Land at Pendle Road, Clitheroe (Standen Phase 5 & 6)

Proposed Residential Development

Comments on Developer's Noise Impact Assessment

Date 9th November 2022

1.8m Brick & Timber Screen Wall

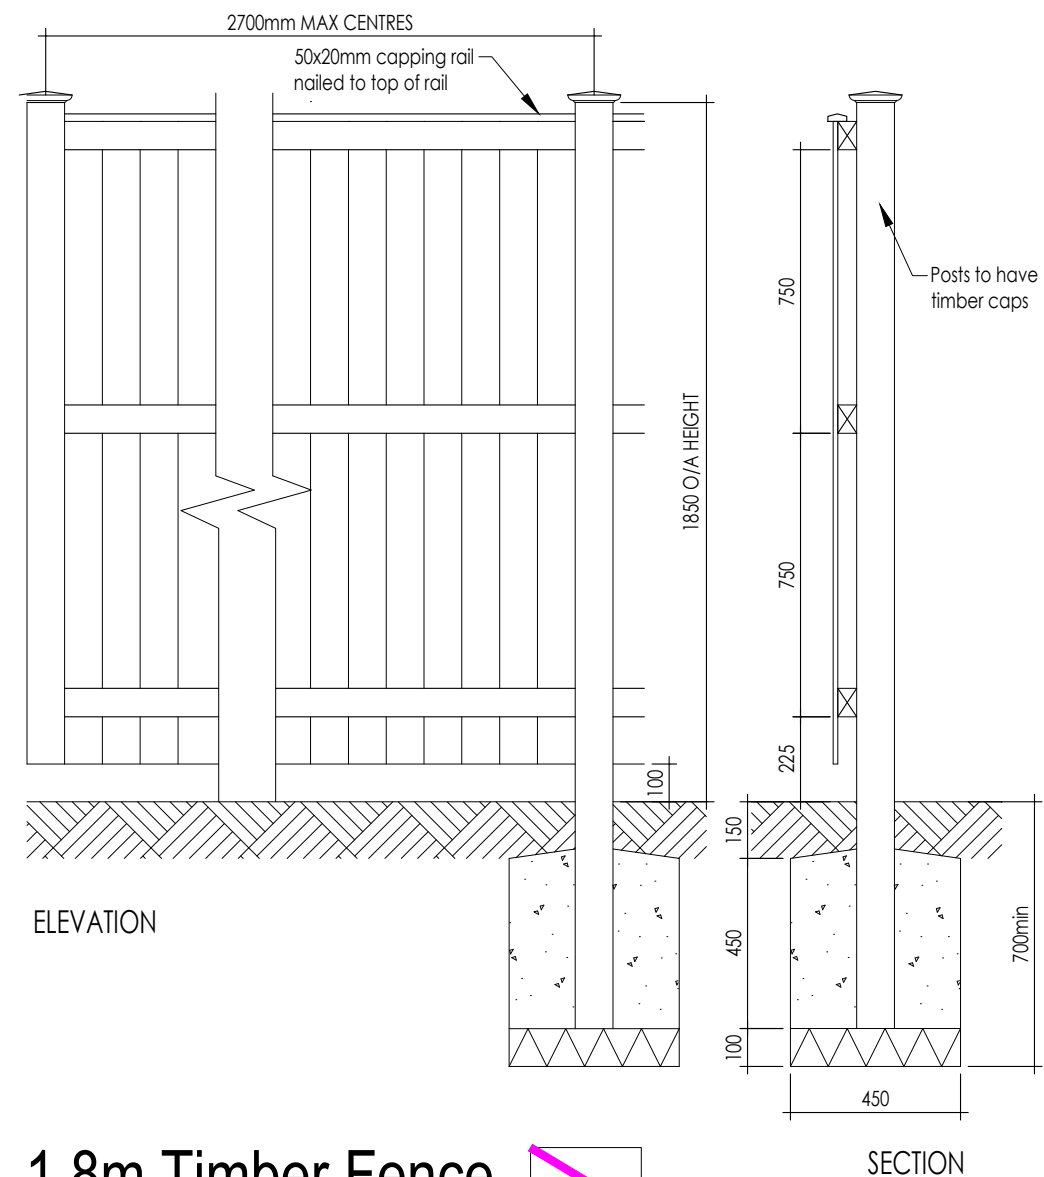
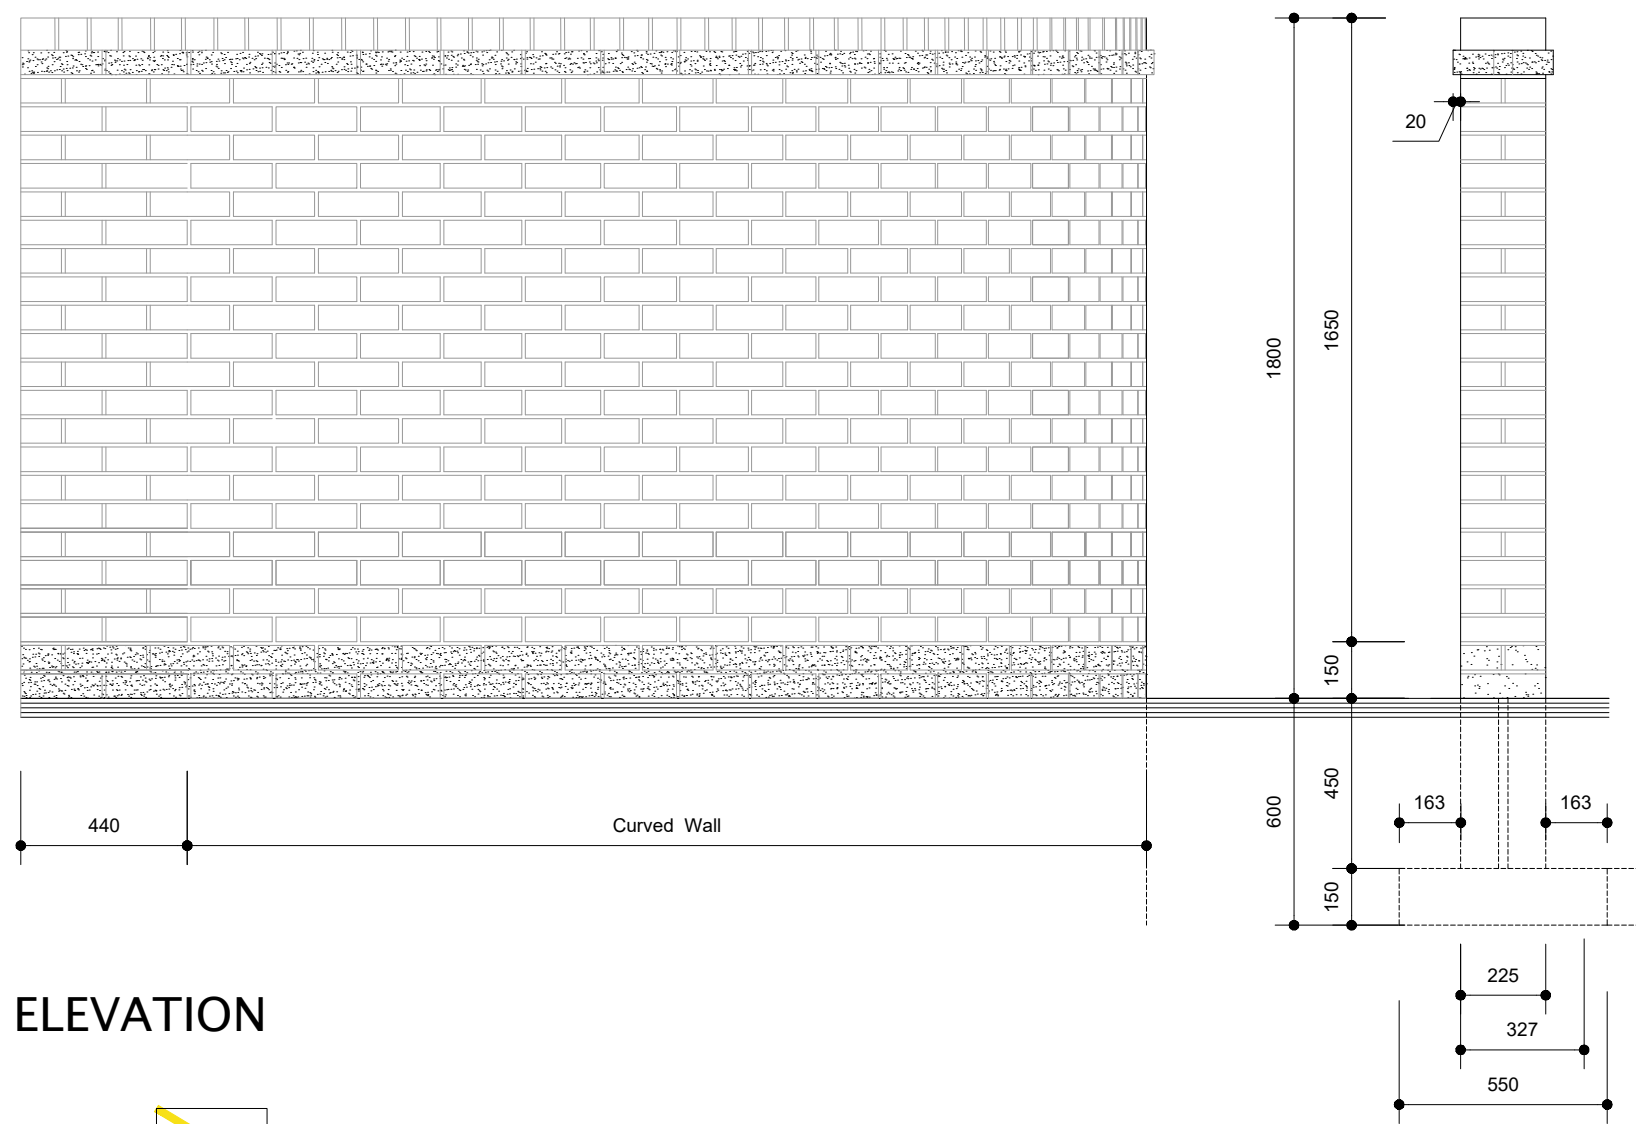
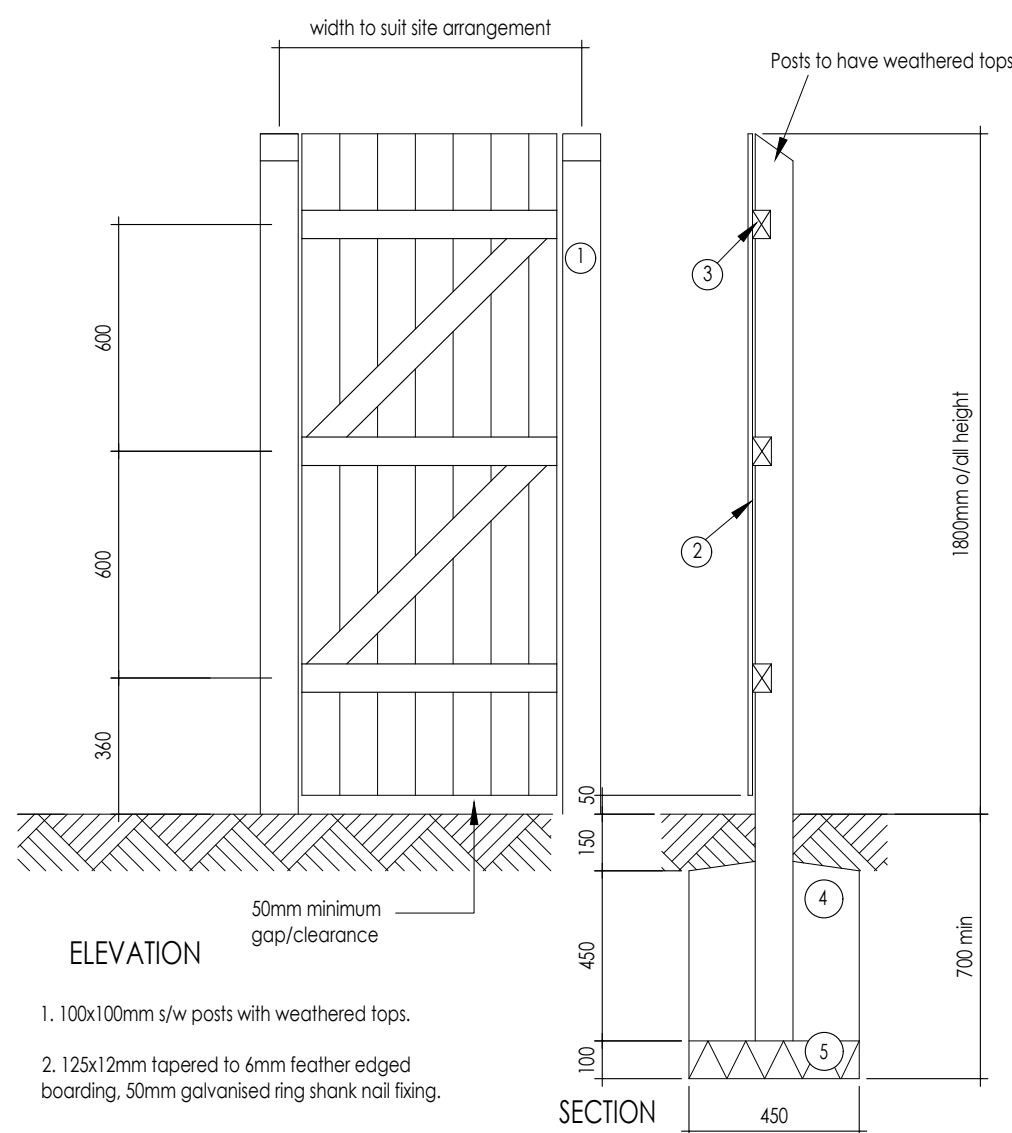
With regard to "*acoustic screening*" 2m high acoustic fencing is recommended for two gardens where the properties are 'sideways on' to any noise from the [REDACTED] however, when protecting against noise sources located in a particular direction, the best solution is to face all the nearest dwellings towards the noise source, with the outdoor amenity spaces on the 'blind' side of the property; this places the amenity spaces both further from the noise source and also uses the dwellings themselves as a screen against the noise. Acoustic fencing can then be used to link between the properties.

Another beneficial [*acoustic screening*] measure that could have been adopted would be an acoustic barrier along the [REDACTED] [REDACTED] which would help reduce noise at the front facades of the properties.

- The package of noise control measures should incorporate the following as appropriate:
 - Erecting an acoustic fence along the boundary [REDACTED]
 - Locating the nearest properties further from the above boundary

- Facing the nearest properties towards the above boundary, placing the gardens on the north side of the dwellings and linking up the dwellings with an acoustic fence
